October 29, 2024

Re: **Responses to Comments 2** –
Harborview Heights – Technical Review 2
SP23-007

DATE: 5-Aug-24
JOB NO: 2023 052
DRAWN: SH
CHECKED: EN
REVISION:
SITE/UTILITY PLAN
SHEET: SP-01

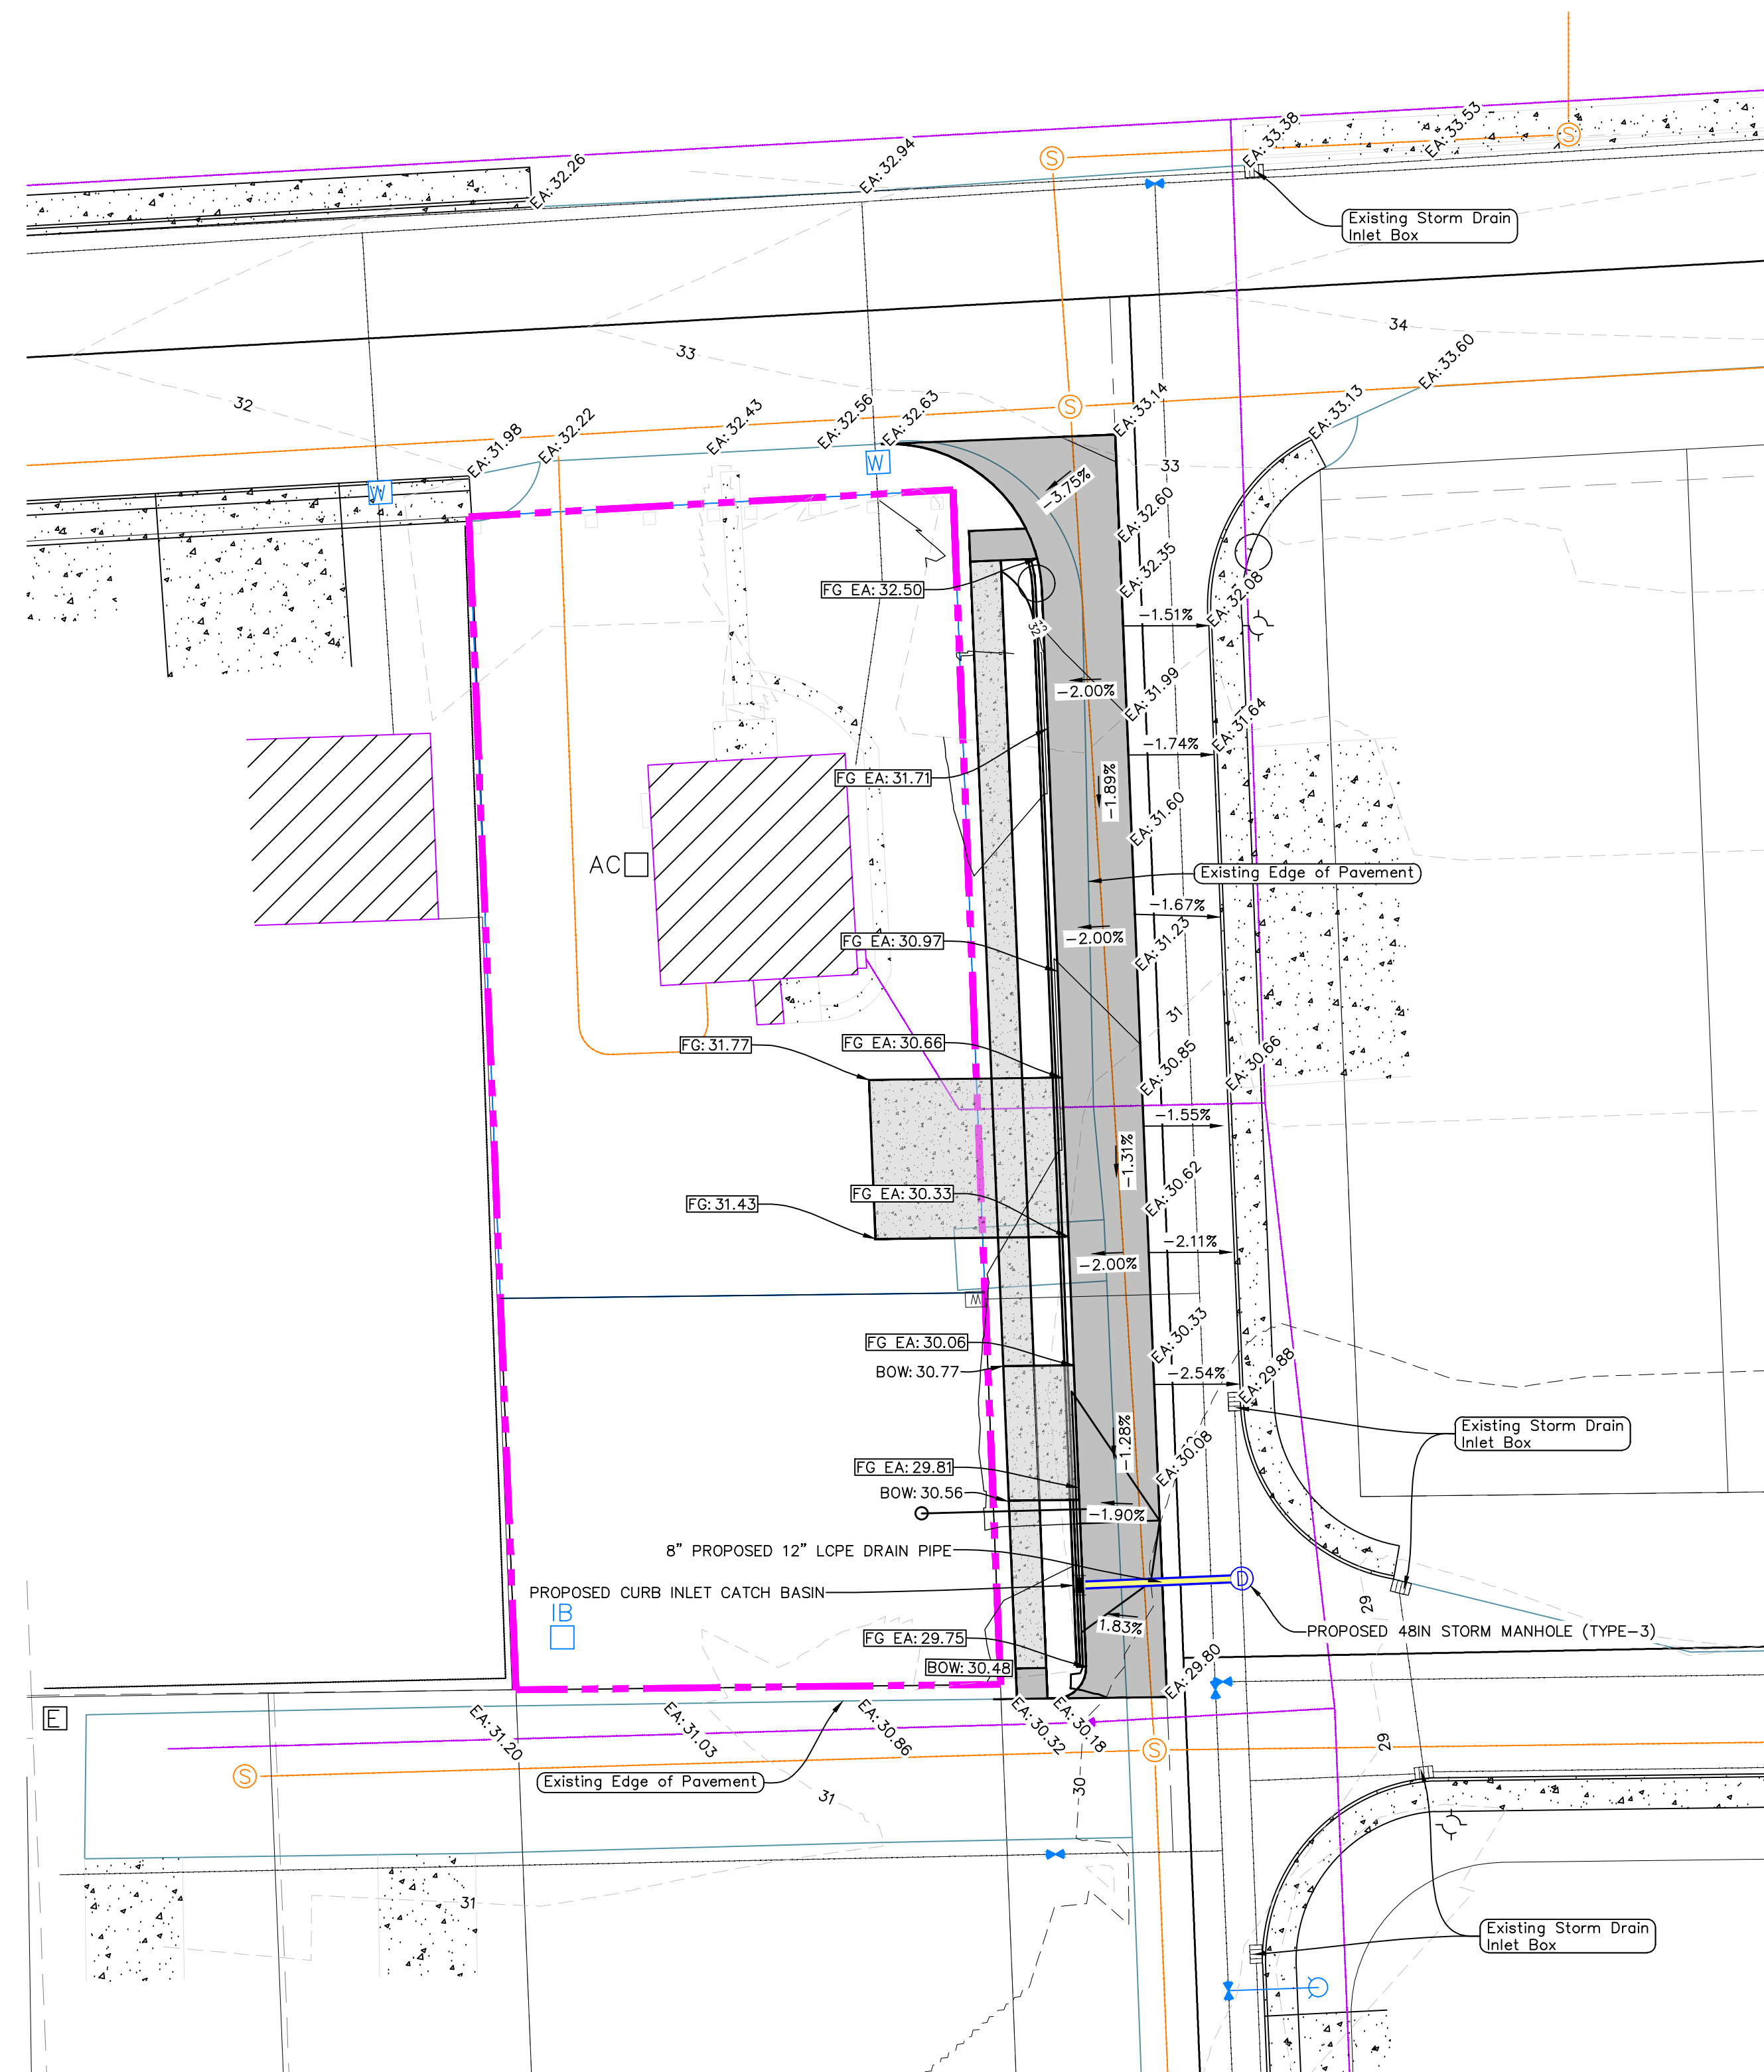
6. On the supplied plans it shows a 4 inch side sewer to the new lot, in the civil submittal the City will require a 6 inch service from the main to the lot.

[Callouts showing 4 inch have been replaced with 6 inch.]

- a. Existing PUD street lighting in area upon 61st ST NE and 52nd Ave NE shall suffice for street lighting requirements.
 - i. Identify existing locations upon site plan within civil construction plans.

[Callouts have been added to street light shown on civil plans (3 locations).]

HARBOR VIEW HEIGHTS
SHORT PLAT
NUMBER SP23-007

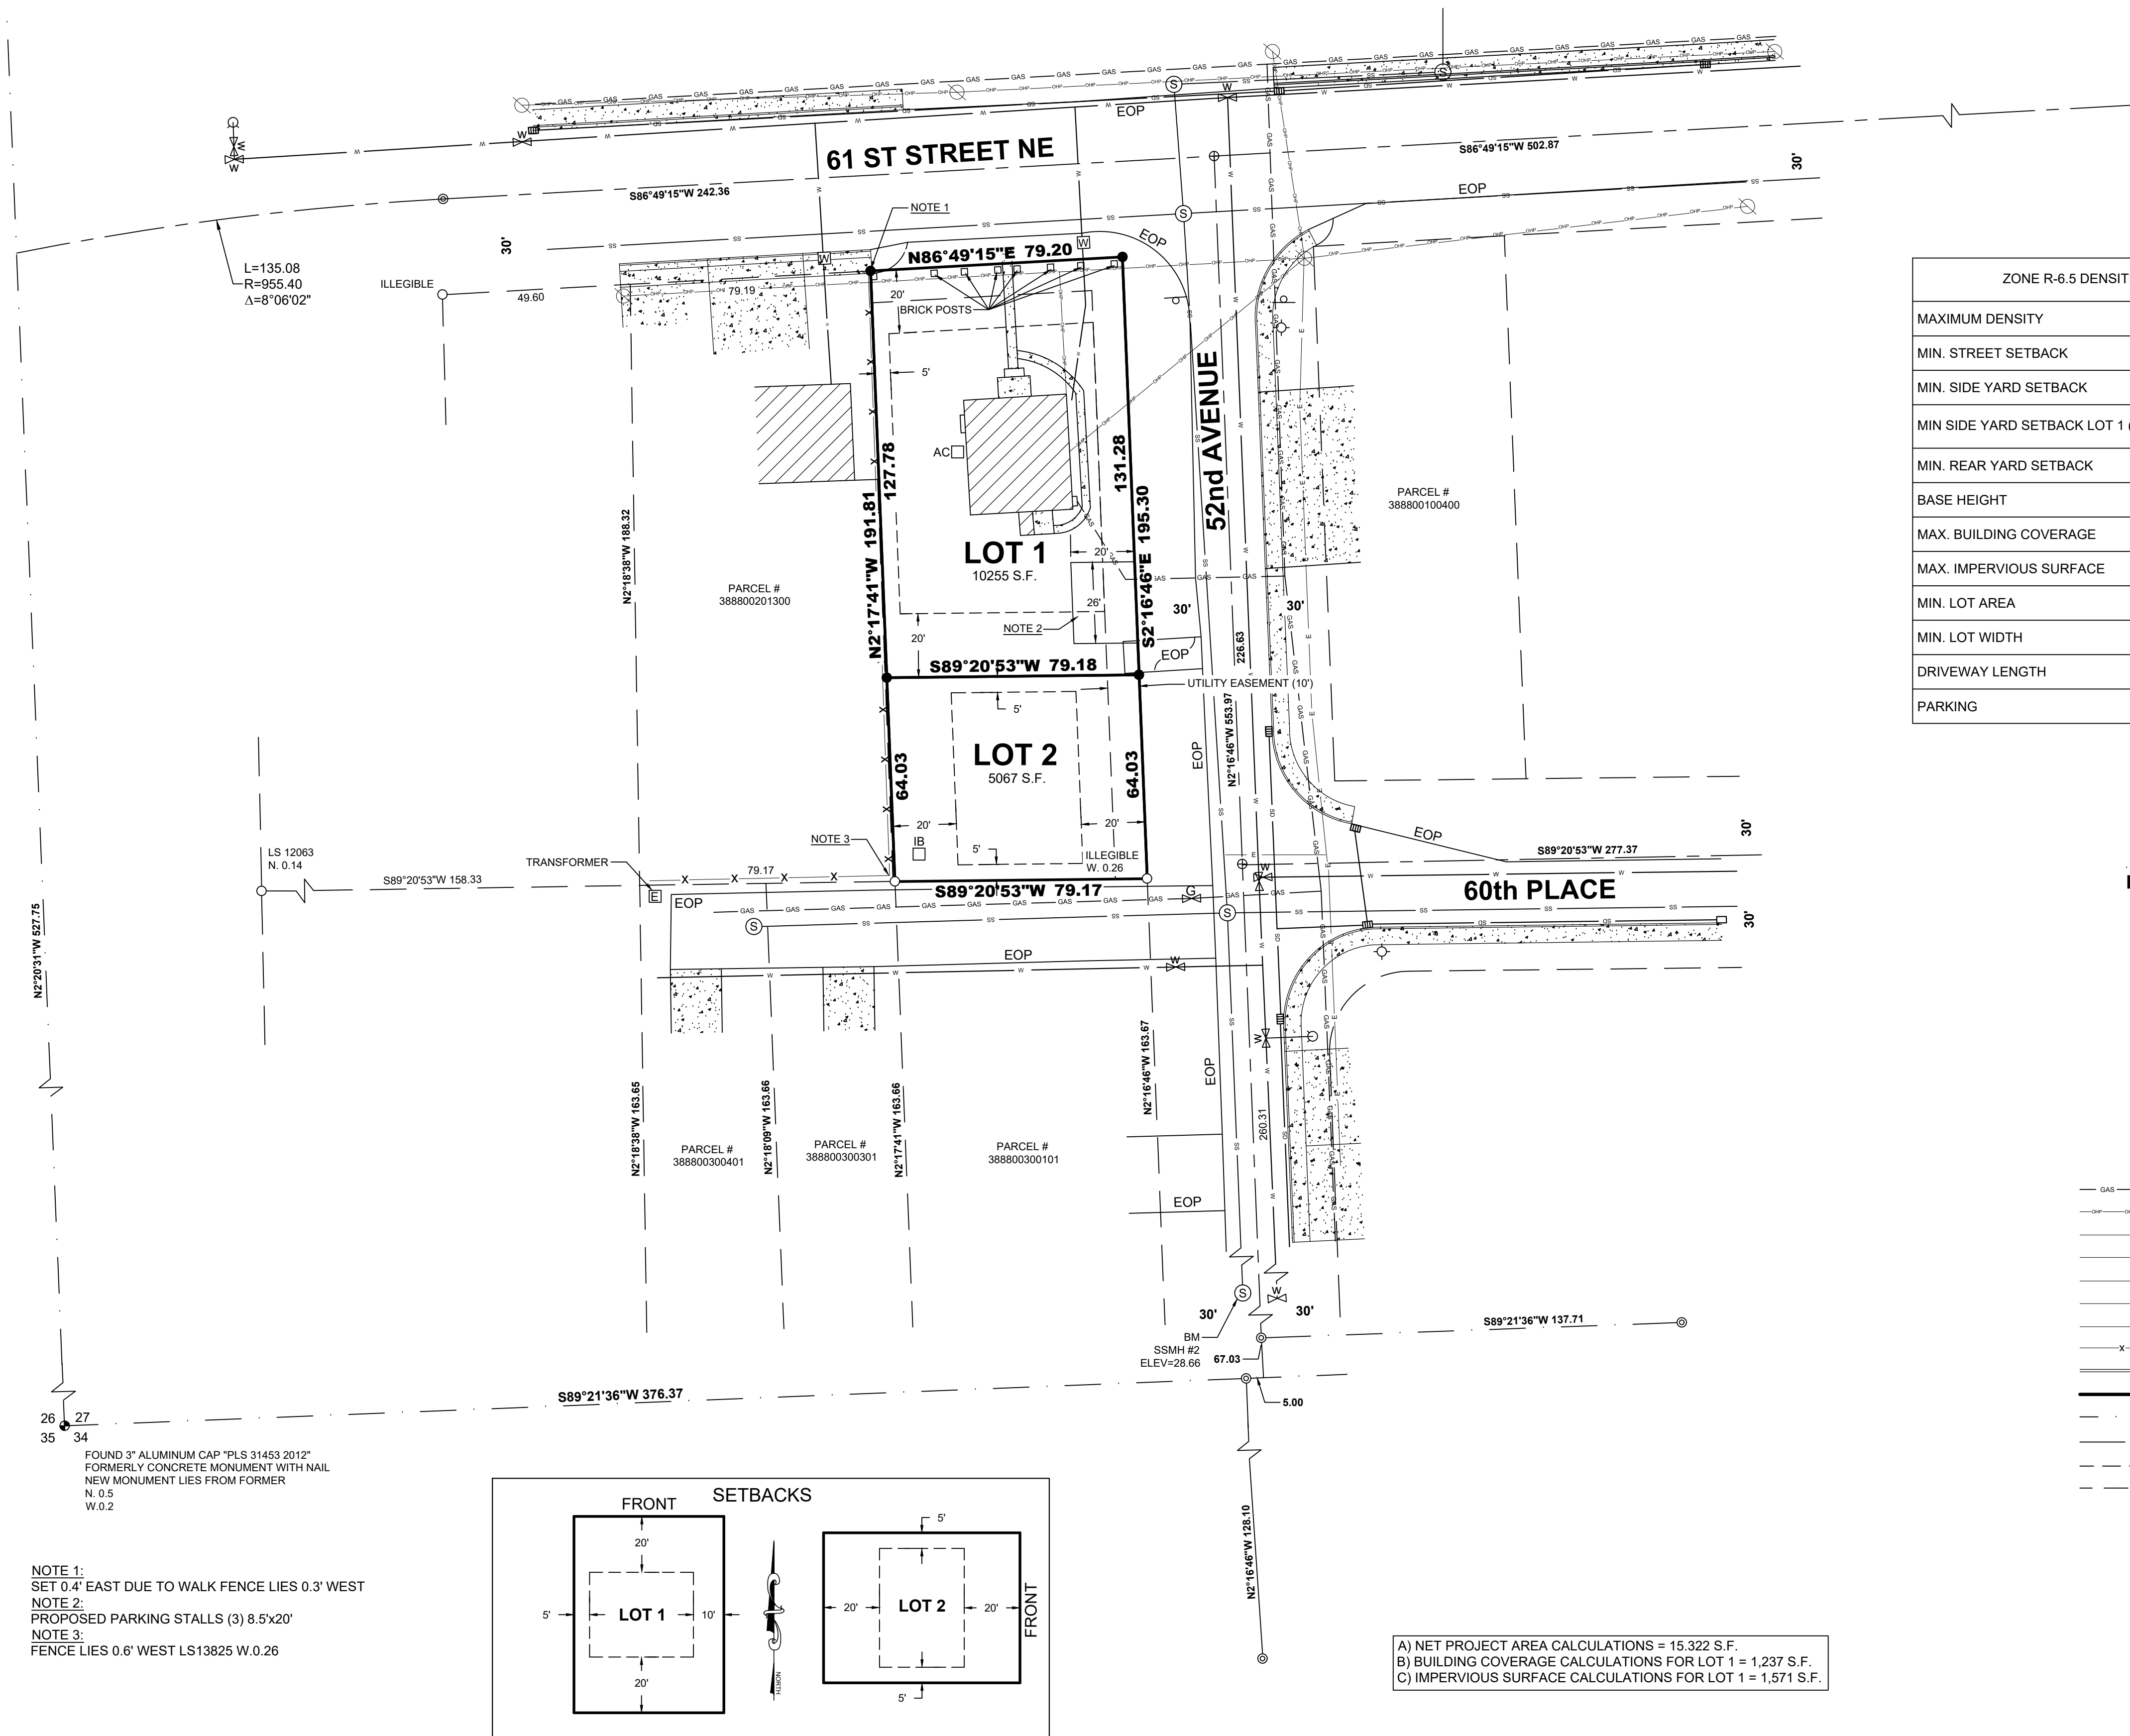
TR2 Comment: Setback lines have not been provided on the preliminary short plat map.

[The setback lines provided on the previous submittal now have dimensions added. In addition, the setback dimensions diagram, previous on Sheet 1 has been moved to Sheet 2 (bottom, middle).]

TR2 Comment: Calculations for net project areas, building coverage and impervious surface coverage have not provided on preliminary short plat map.

[The requested calculations were provided. They have now been placed in a box.]
